Our ref: WA/2019/127068/01-L01
Your ref: 19/01705/OUT
Date: 03 October 2019

Outline planning application for the erection of up to 95 dwellings with public open space, landscaping and sustainable drainage system (SuDS) and vehicular access point from South Newington Road. All matters reserved except for means of access

Land Adjoining and West of Bloxham Recreation Ground, South Newington Road, Bloxham

Figure 3.10: Map showing extent of Flood Zones and areas of surface water flooding.

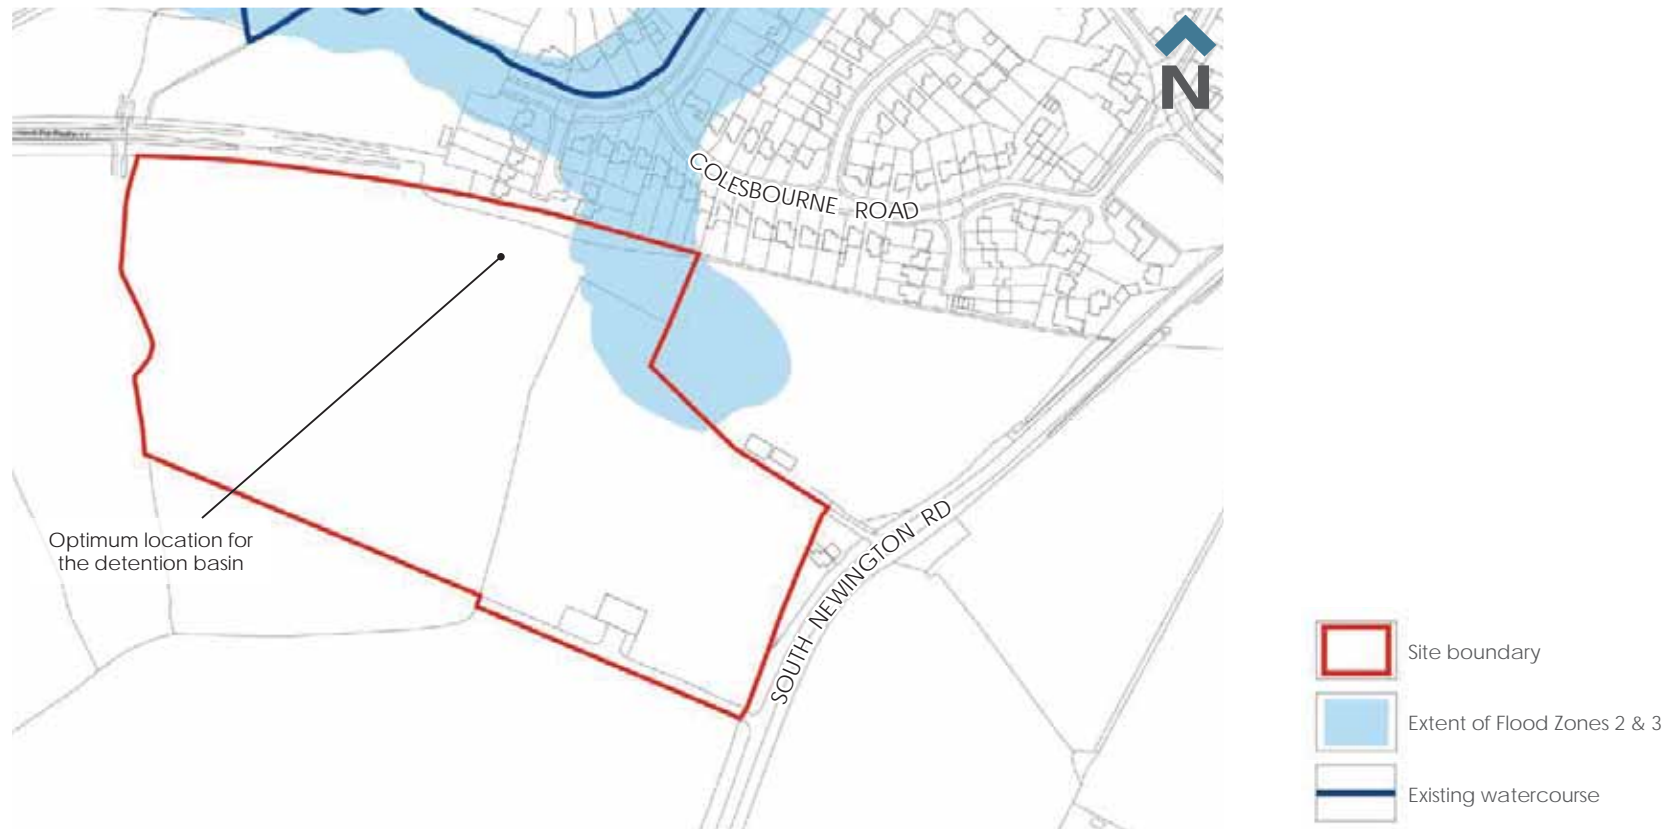
The application site is located within Flood Zones 1, 2 and 3 and as such is at risk of flooding. We are pleased to see that a site specific Flood Risk Assessment has been submitted. Unfortunately, having reviewed this document we have identified a number of concerns which will need to be addressed.

Furthermore, we do not have any detailed modelling in this area. Cherwell District Councils Level 1 Strategic Flood Risk Assessment, states that in the absence of detailed modelling, a precautionary approach should be applied which assumes that Flood Zone 3a represents Flood Zone 3b.

The PPG classifies development types according to their vulnerability to flood risk and provides guidance on which developments are appropriate within each Flood Zone. This site lies within Flood Zone 3b functional floodplain, which is land defined by your Strategic Flood Risk Assessment as having a high probability of flooding.

The applicant will need to undertake detailed modelling to demonstrate that the site is not located within Flood Zone 3b.

As there is currently no detailed modelling in the area of the site we are aware that you have undertaken a basic assessment to derive the 1 in 100 (1%) flood level and the 1 in 1000 (0.1%) flood level for this site. However, for a development type of this size a more detailed assessment will be needed to establish the flood levels for this site. We would expect the applicant to undertake a detailed modelling exercise.

In addition the approach taken to assess the impact of climate change is not appropriate for the development type proposed. For this development type we would expect the applicant to undertake a detailed modelling exercise in order to establish the 1% annual probability (1 in 100) flood level with an appropriate allowance for climate change.

The applicant has therefore not demonstrate to our satisfaction whether there will be a loss of floodplain storage up to the 1% annual probability (1 in 100) flood extent with an appropriate allowance for climate change. In the event that the proposal will result in a
